ENG-CDR19004-R3-RD-CDs-Redlines .pdf Markup Summary

Subject: EPC ENG Review
Page Index: 1
Date: 8/19/2020 3:56:46 PM
Author: dsdrice
Color: ■
Layer:
Space:
Page Label: [1] 1 COVER SHEET

Subject: Cloud+
Page Index: 5
Date: 8/19/2020 11:51:21 AM
Author: dsdrice
Color: ■
Layer:
Space:
Page Label: [5] 5 MERIDIAN ROAD DRAINAGE PLAN

MERIDIAN ROAD DRAINAGE PLAN

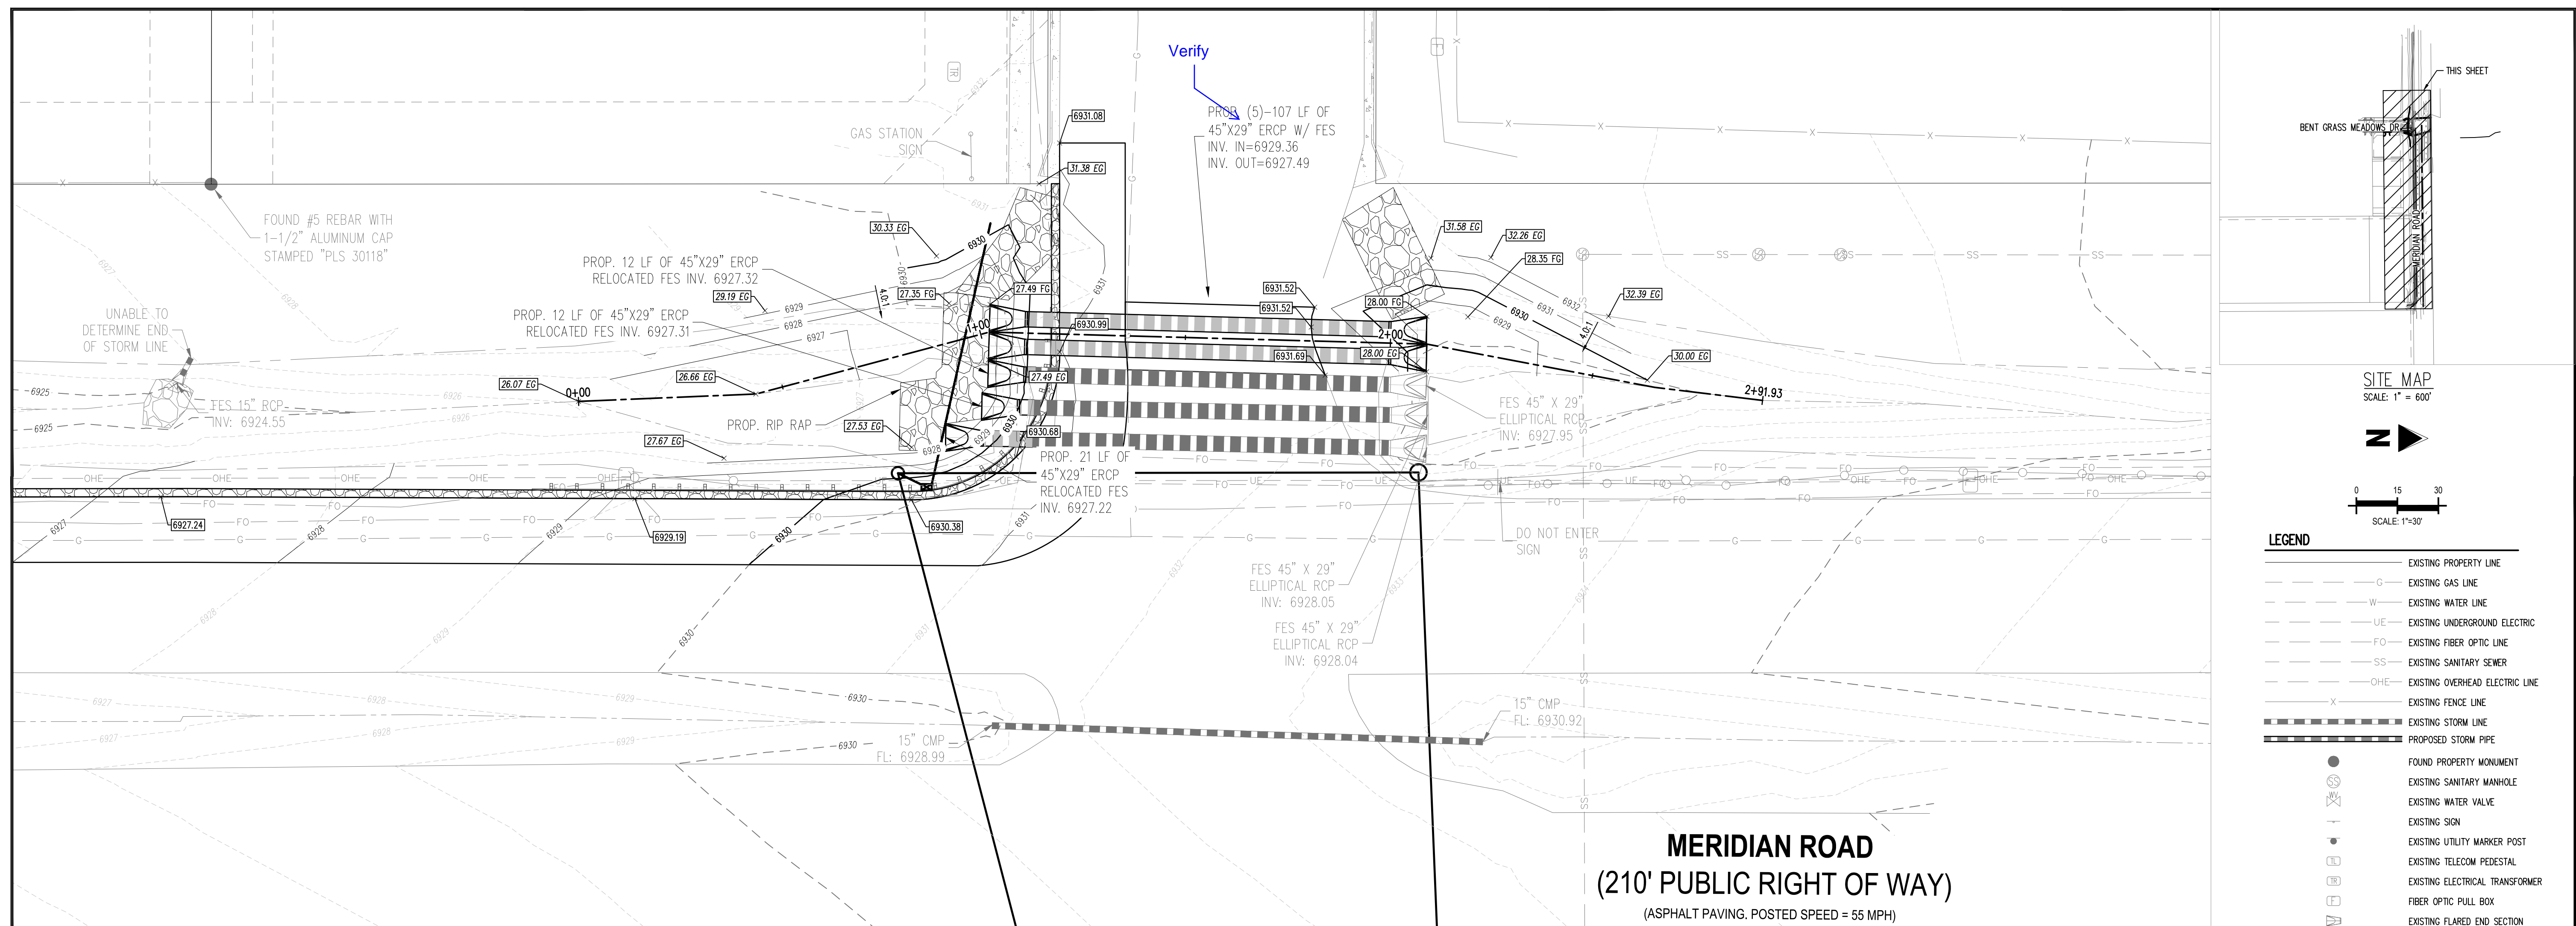
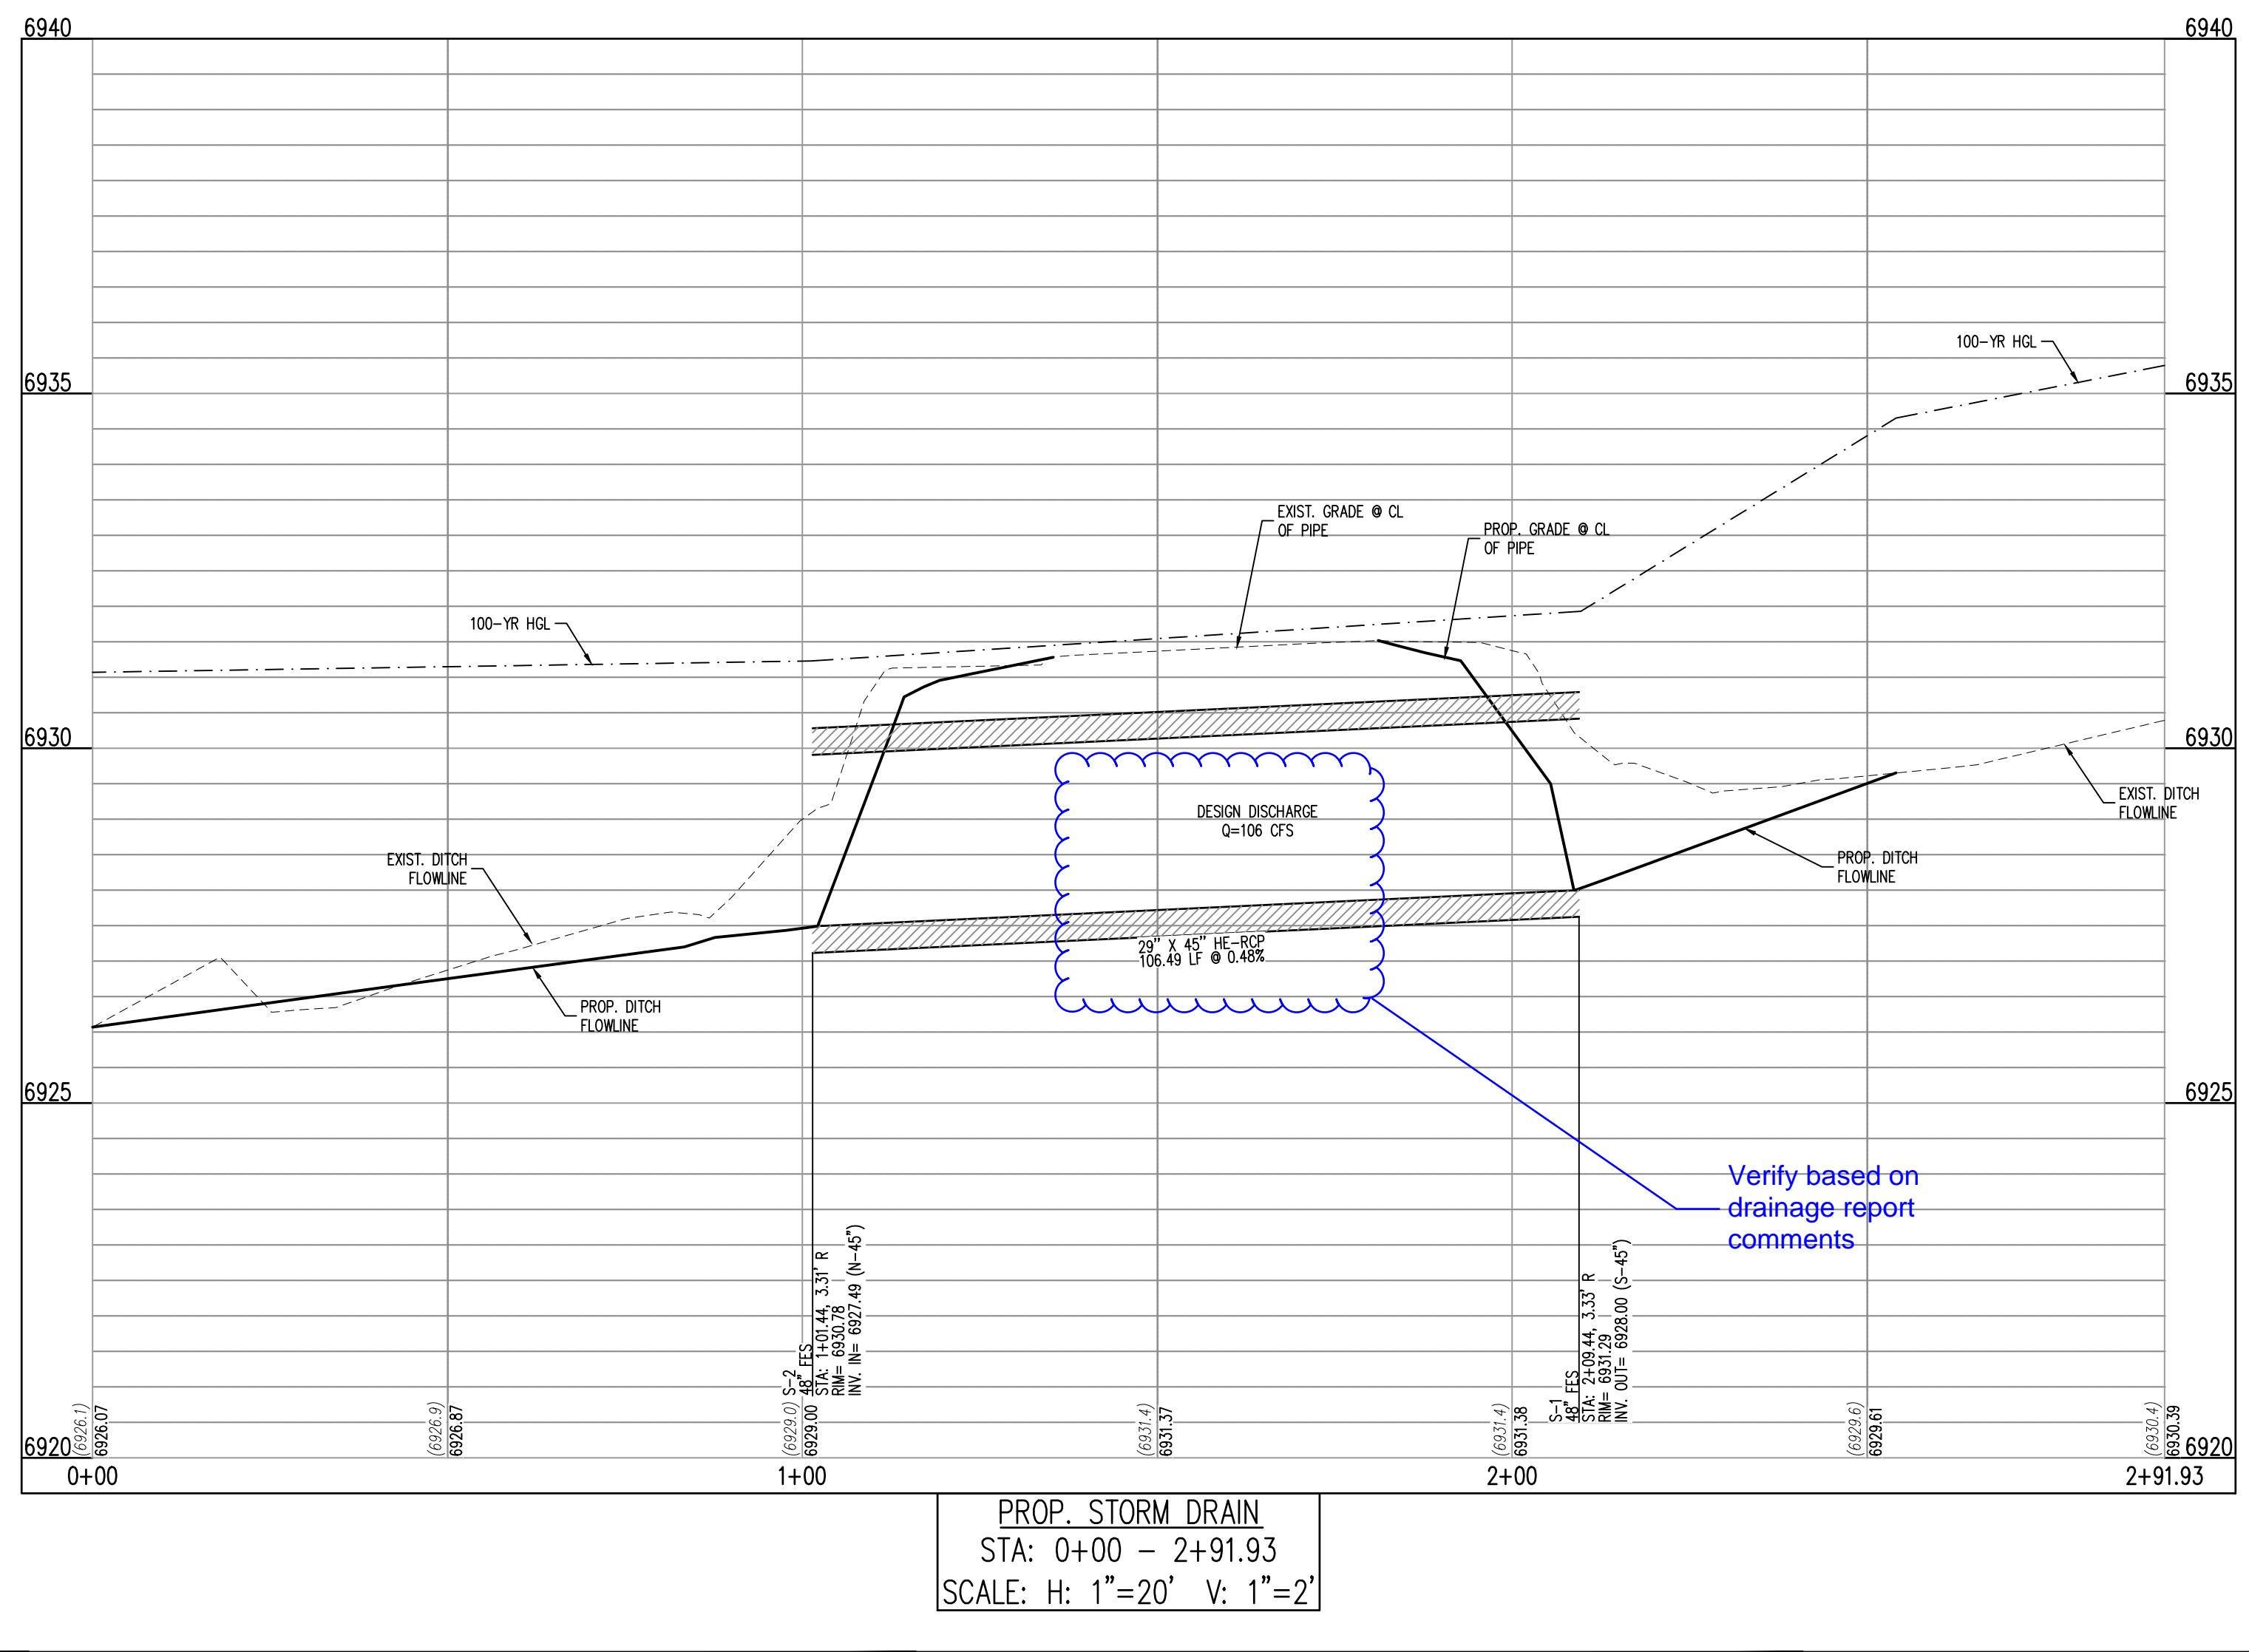
Verify based on drainage report comments

Verify
